PL- Rep- Arun Conservation Area Advisory Panel response

From: Brian Banister [REDACTED]
Sent: 17 March 2026 16:50
To: Planning.Responses <Planning.Responses@arun.gov.uk>
Subject: Arun Conservation Area Advisory Panel comments on applications

R/37/26/PL - Church of St Peter and St Paul, The Street, Rustington
No Objection

THE CHURCH OF ST PETER & ST PAUL
RUSTINGTON, WEST SUSSEX:
PROPOSED PV INSTALLATION
FLOOR & ROOF PLANS, ELEVATIONS

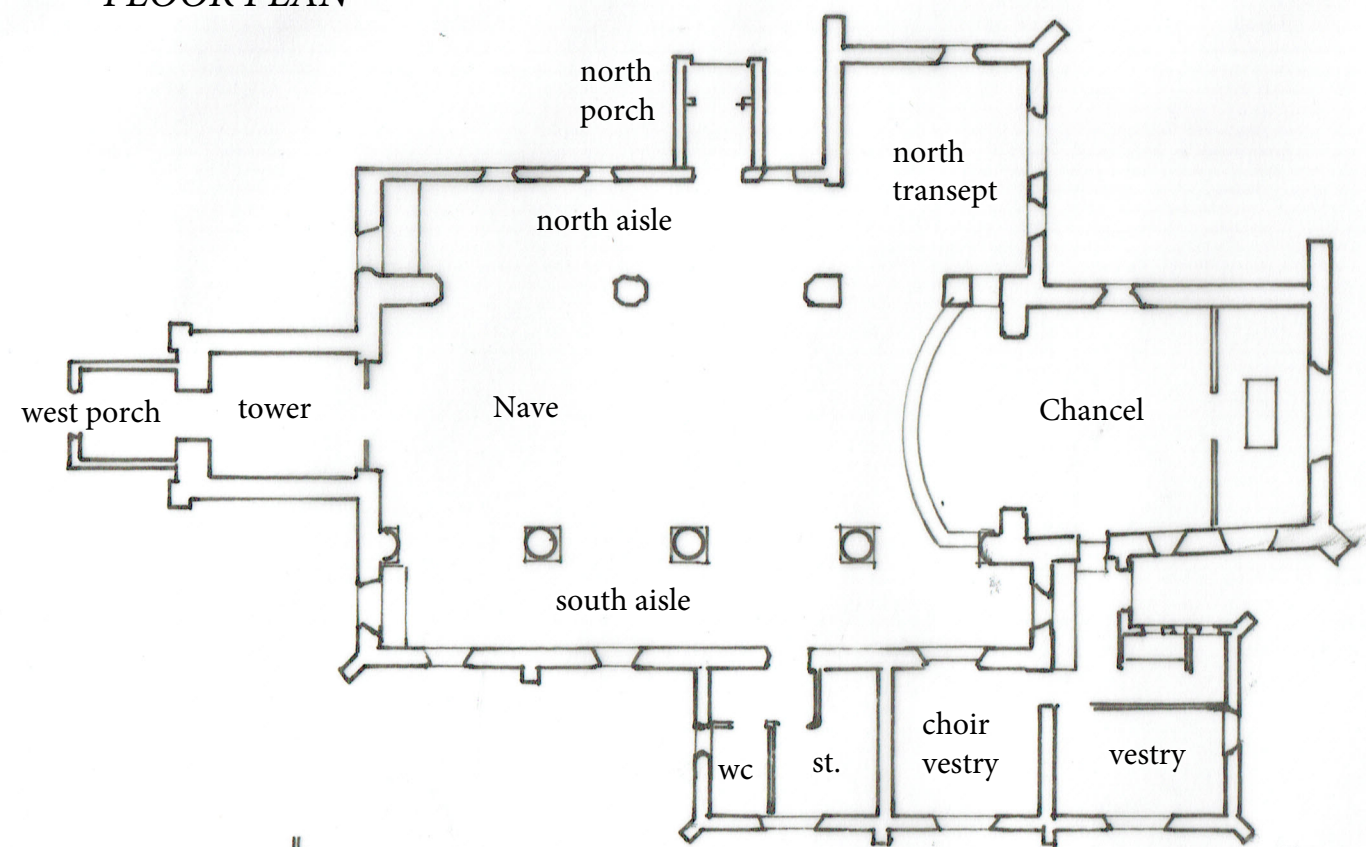
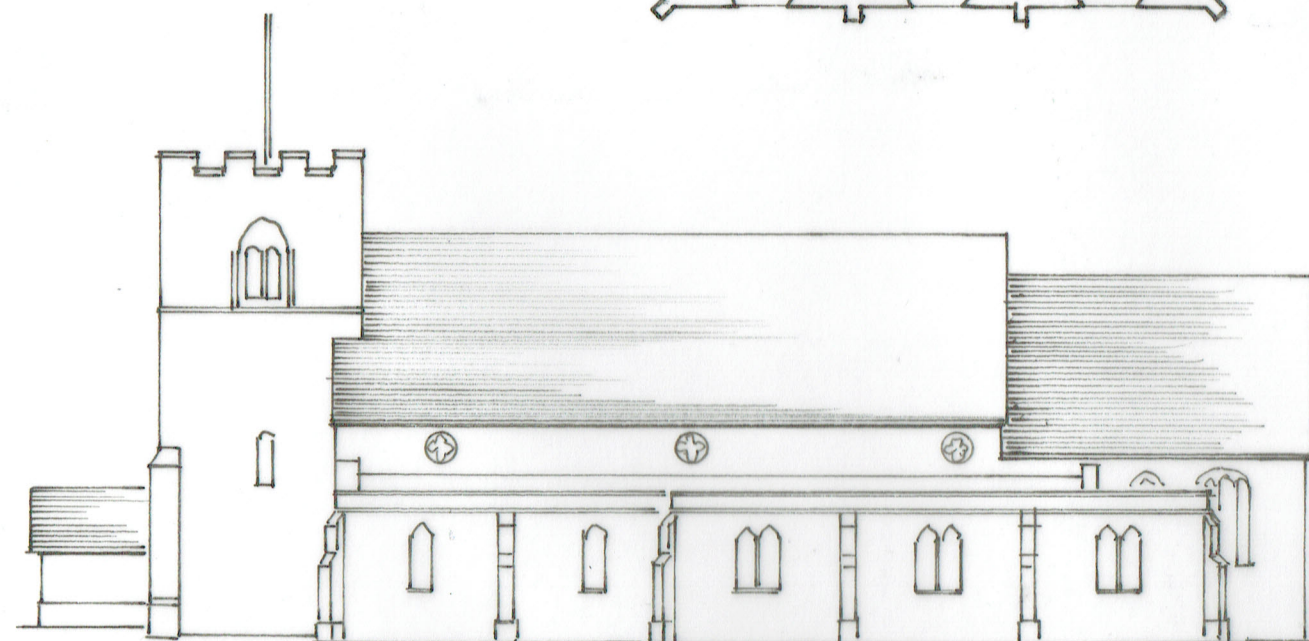
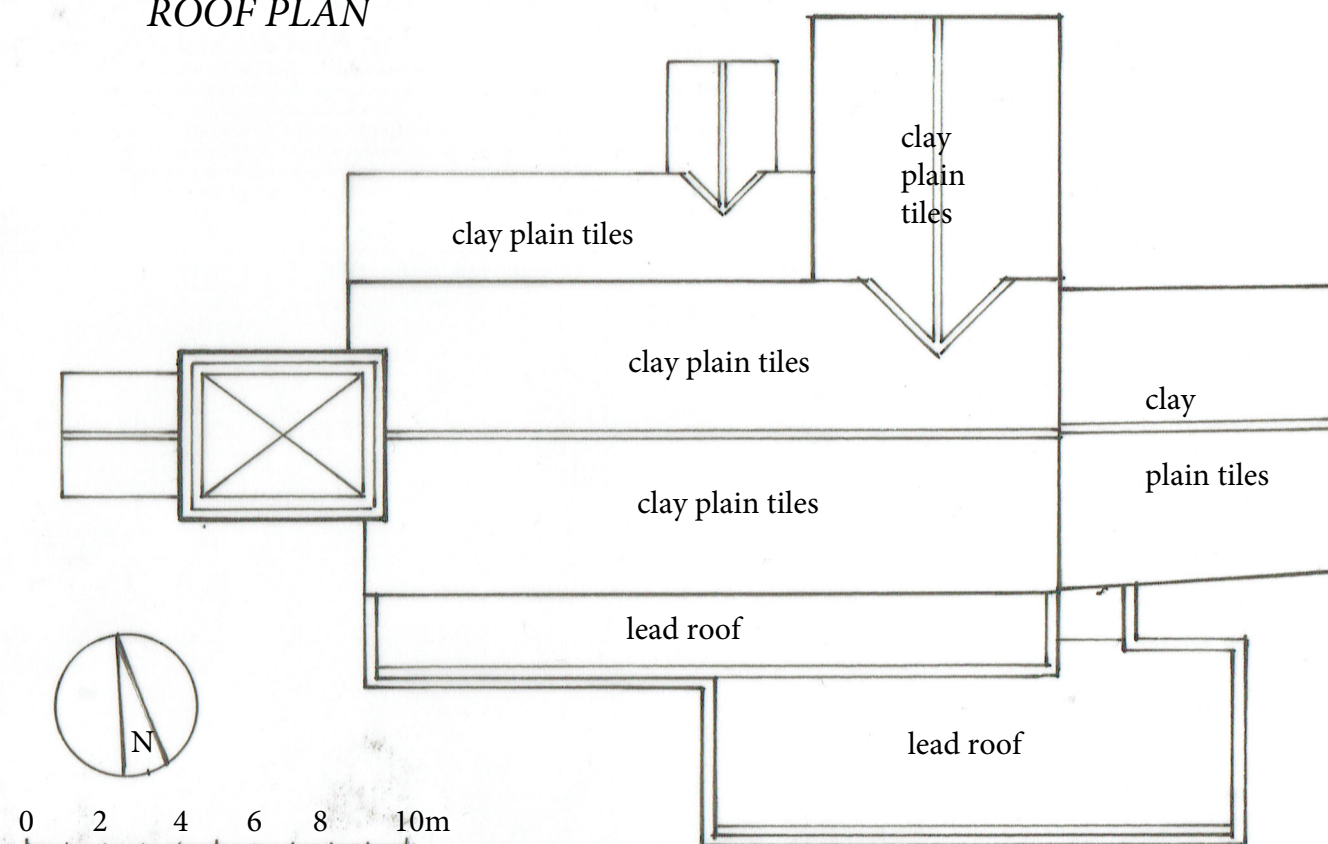
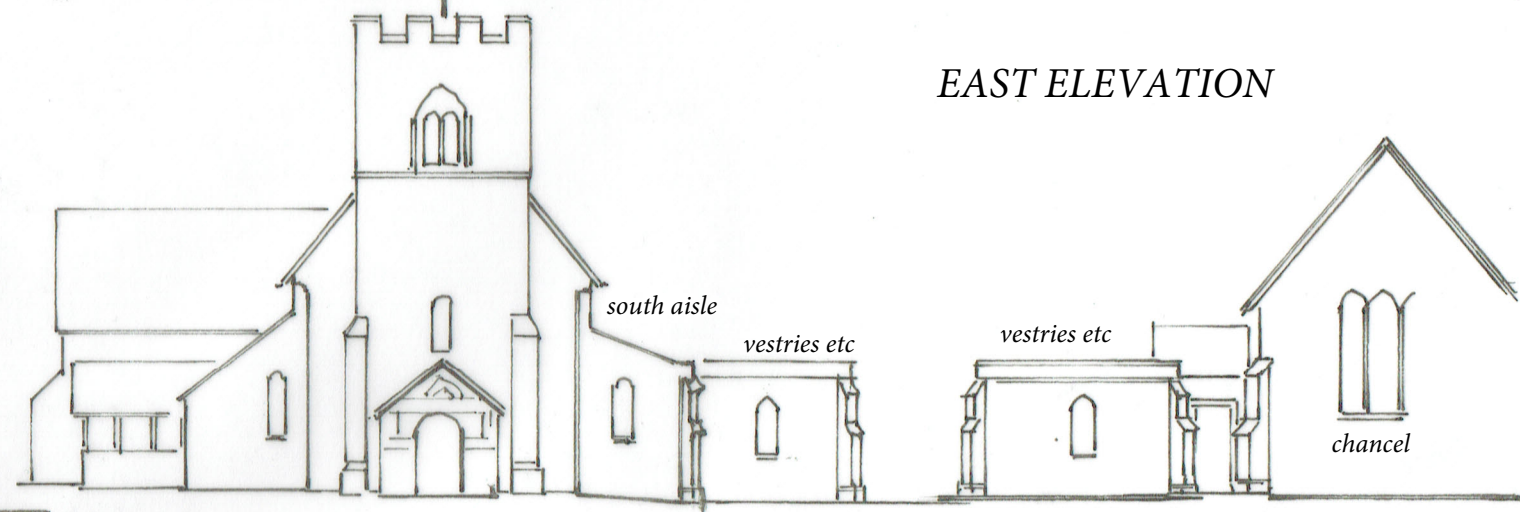
The Panels will be substantially hidden by the parapets and there will be no harm to the character and appearance of the conservation area.
